## **HINCKLEY NATIONAL RAIL FREIGHT INTERCHANGE**

### **The Hinckley National Rail Freight Interchange Development Consent Order**

### **Applicant's Comments on Local Impact Reports [Appendix A – Applicant's Response to LUC Design Review]**

**Response to the Landscape Design Review**  
**Prepared by LUC in respect of Hinckley National Rail Freight Interchange (HNRFI)**  
**October 2023 v.5**

Fig 3. Existing Bridleways and Public Rights of Way

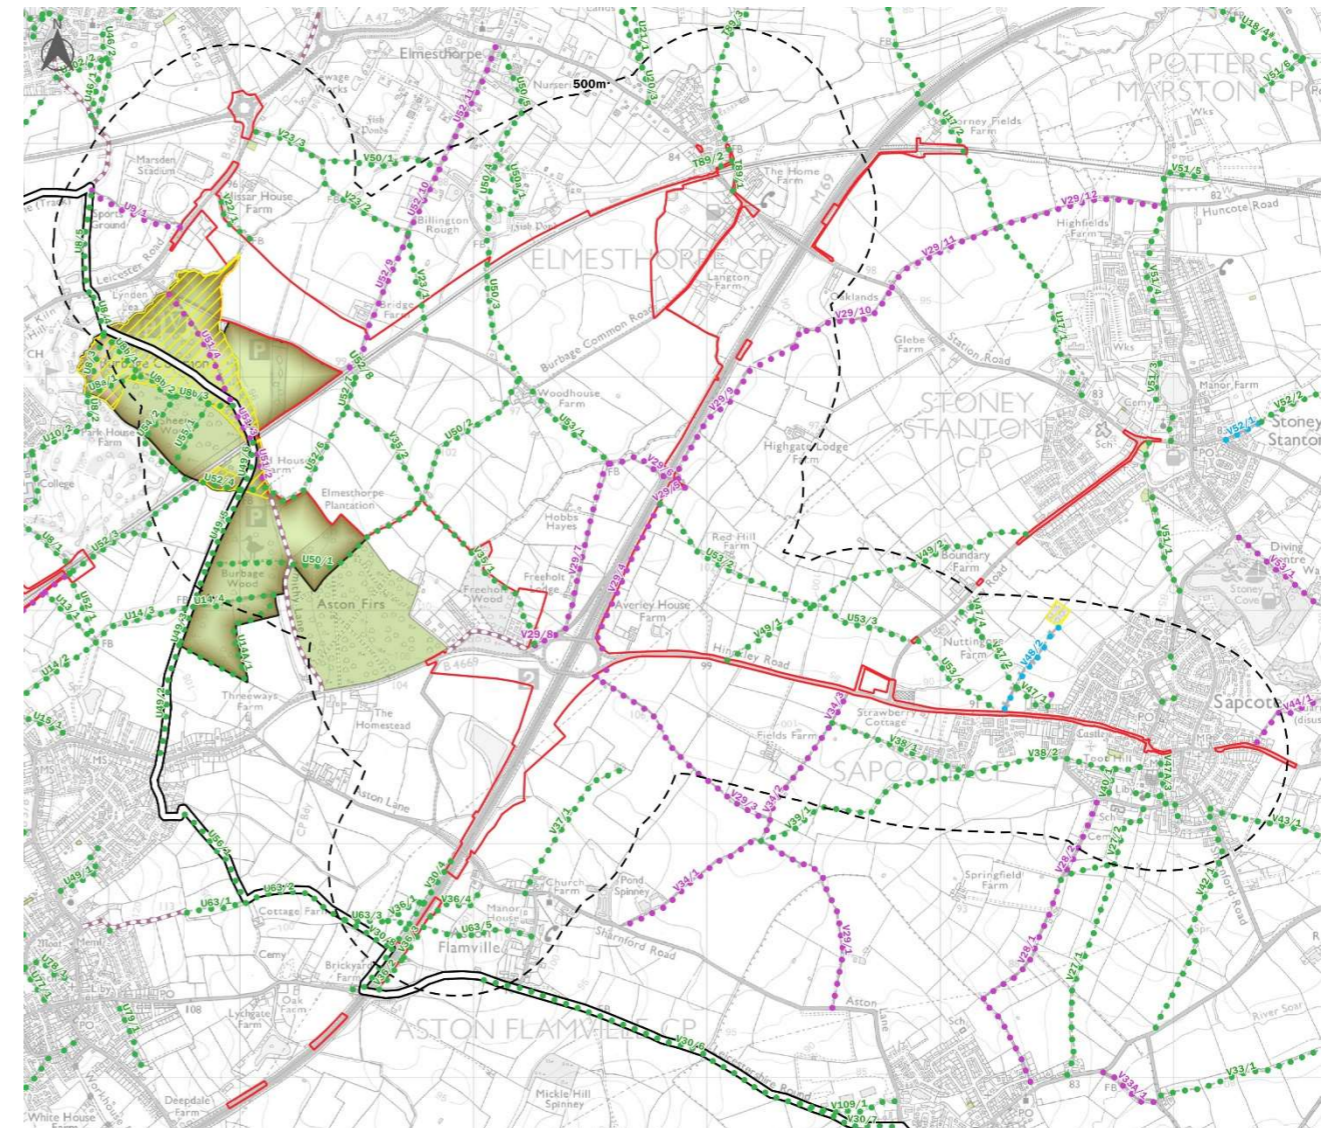
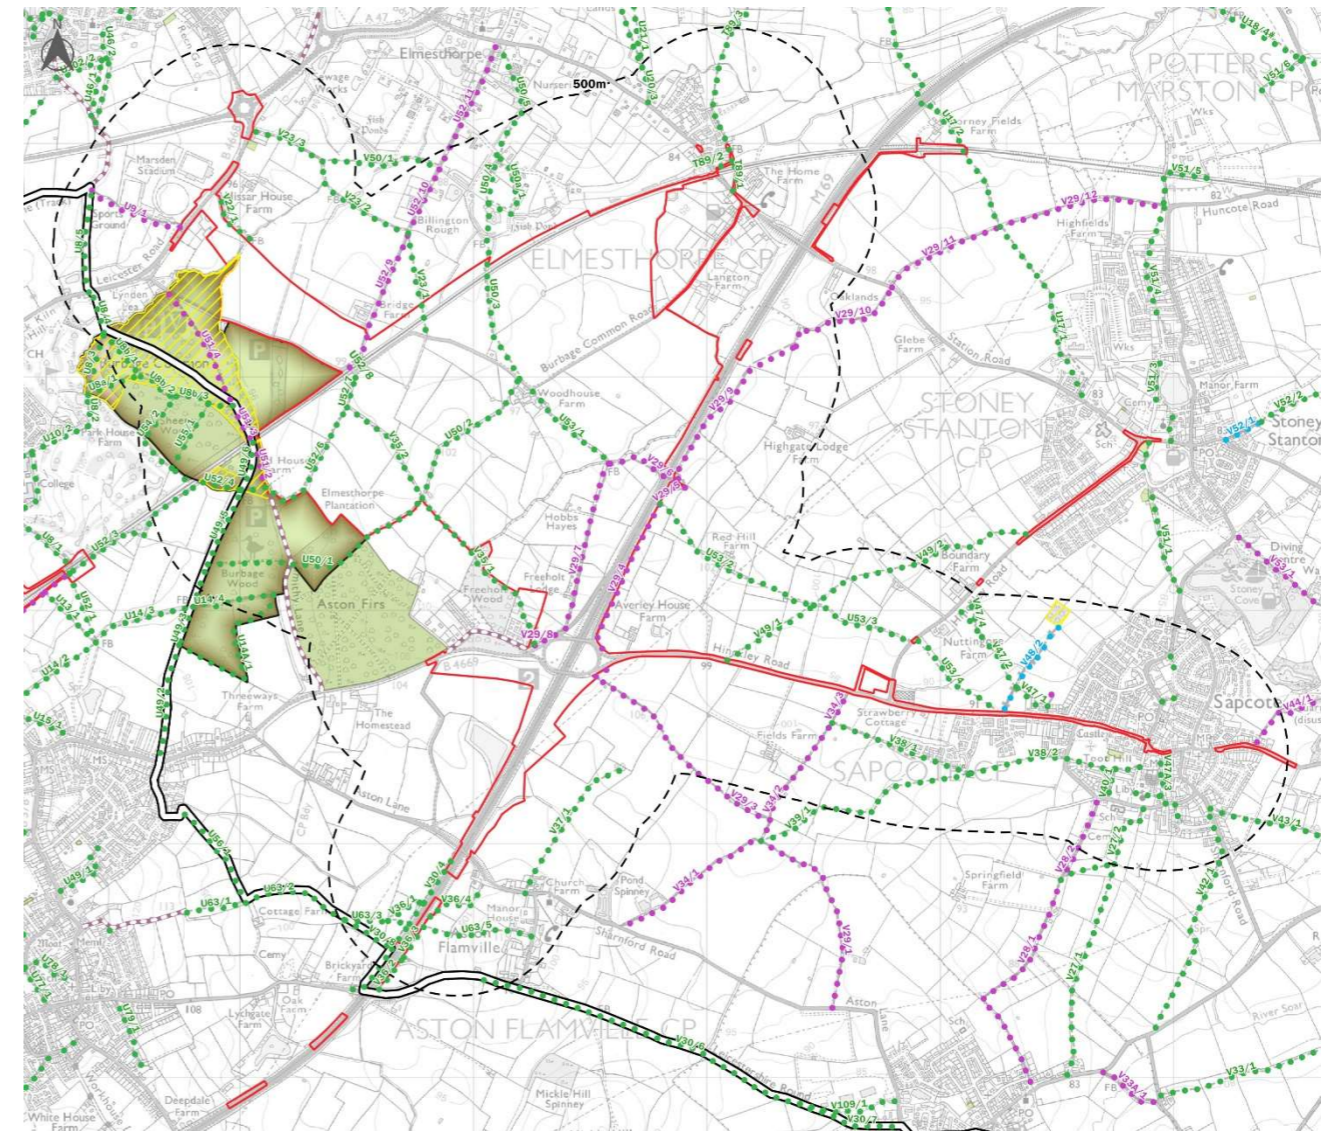
<p>Section 2.4, Existing PRoW, pg 17</p>	<p>TSH are re-routing the existing PRoW where they interact with the main HNRFI site. Similarly, where level crossings form part of existing routes, they are proposed to be closed, following discussions and agreement with Network Rail. It is not true that TSH are directing the public along the internal estate roads. TSH is not precluding the opportunity to do so, but directional signage, will, in the first instance, lead the public to and around the site, through the landscape corridors of the new Bridleways.</p>	<p>Section 8 Design Code 04, pgs 20,21 and 22.</p>

Fig 6. Parameters Plan and Key

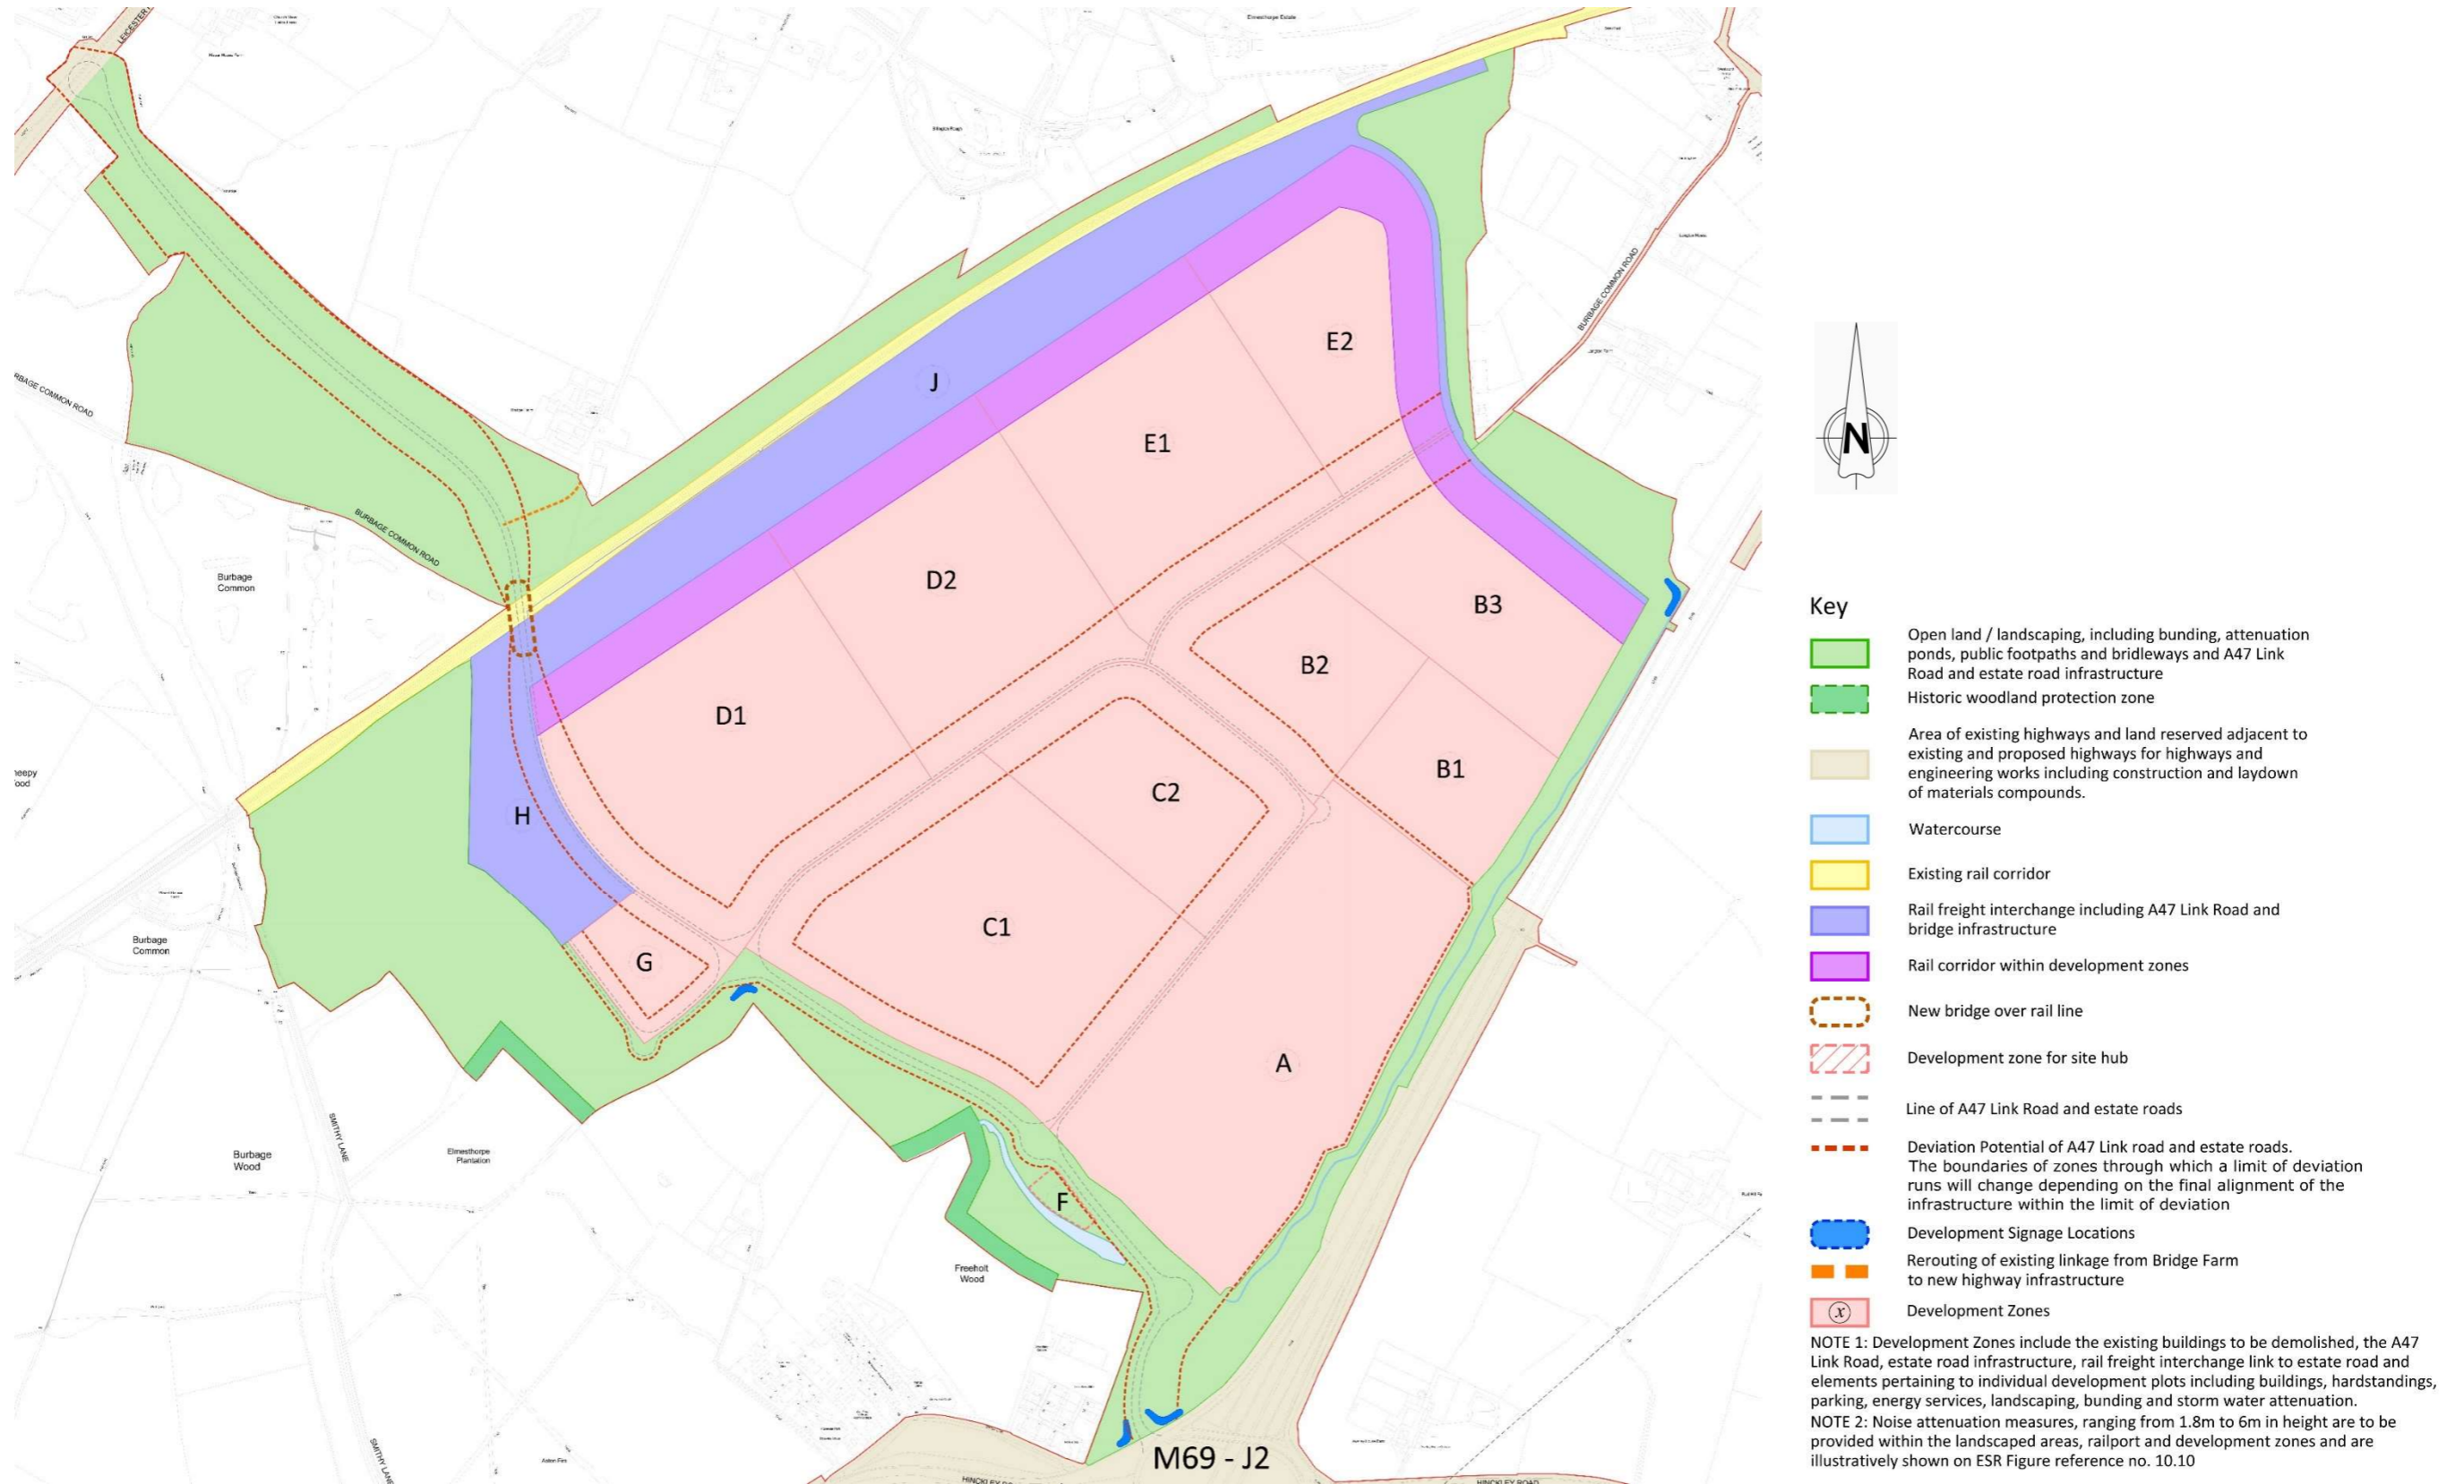
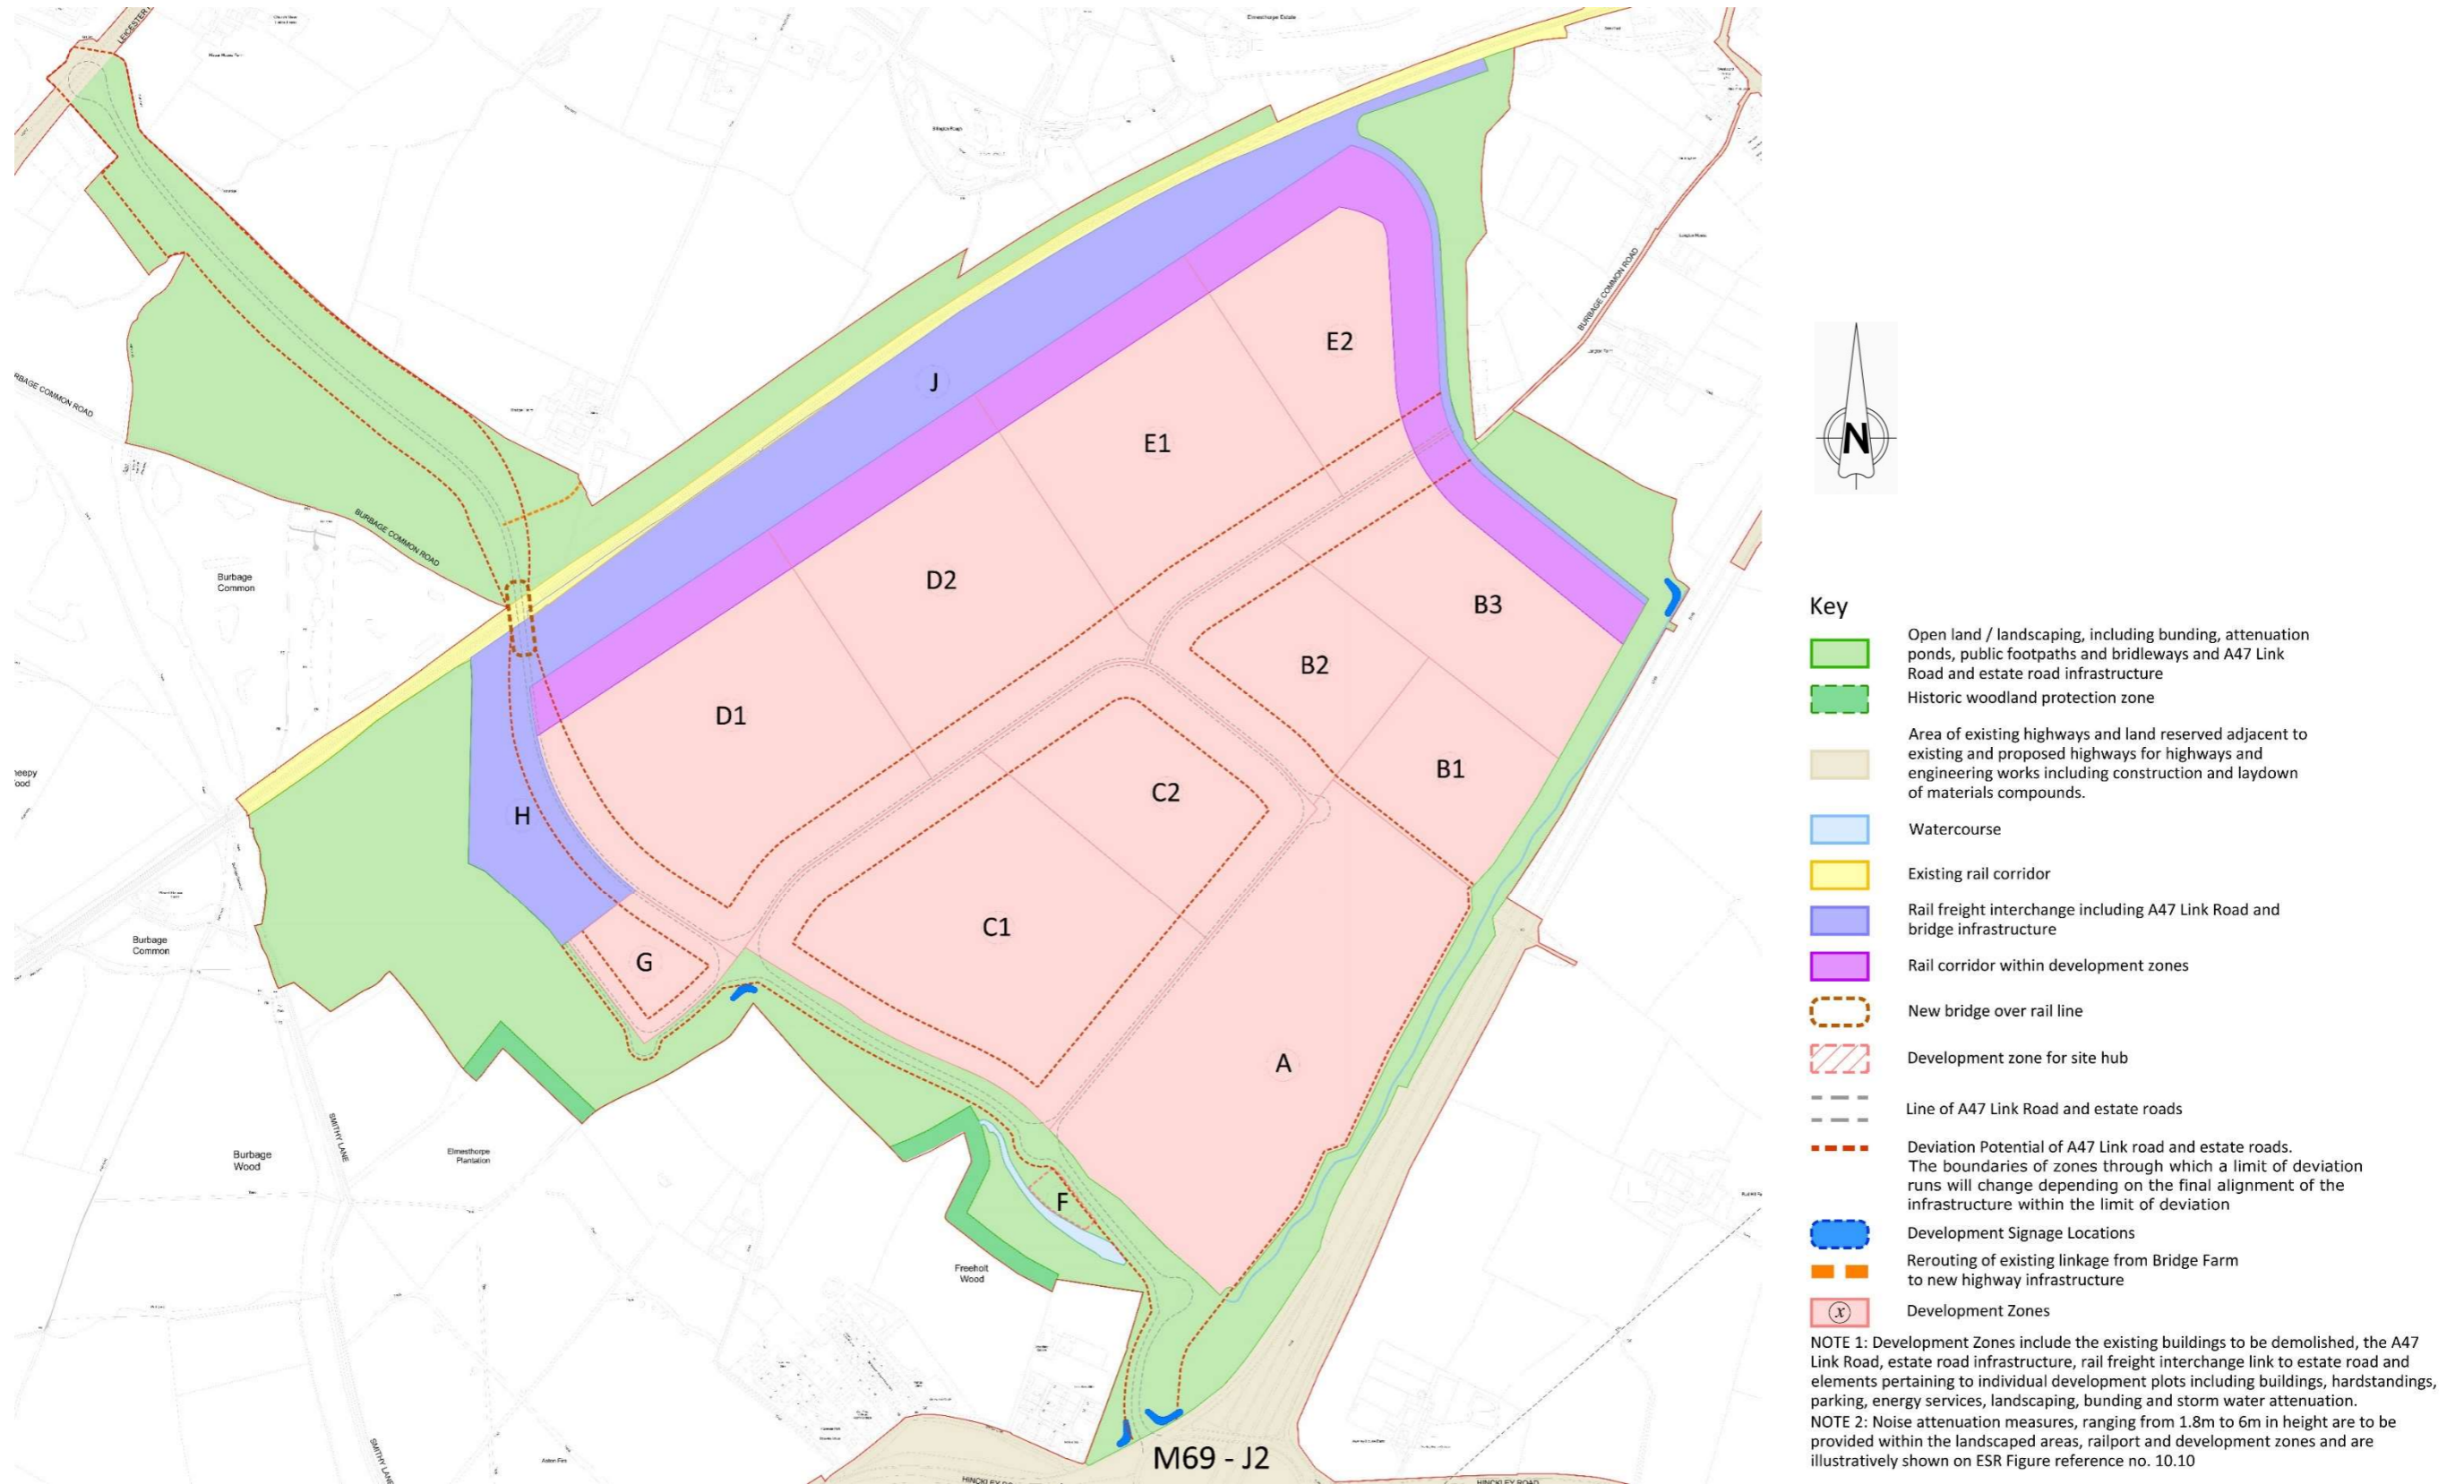
Section 2.3, Scale and Massing Pg15	<p>The LUC assessment, appears to use the nine illustrative buildings as a definitive. The fact is, there could be any number of other permutations on unit numbers and sizes, as is recognised on the Parameters Plan, which will affect the overall scale and massing of the final development.</p> <p>LUC are correct in their statement that the massing would not relate to the local area, but it has to be measured in the context of the functionality of a SRFI, and for that, the units shown are entirely appropriate and are designed to appeal to the widest range of</p>	NOTE
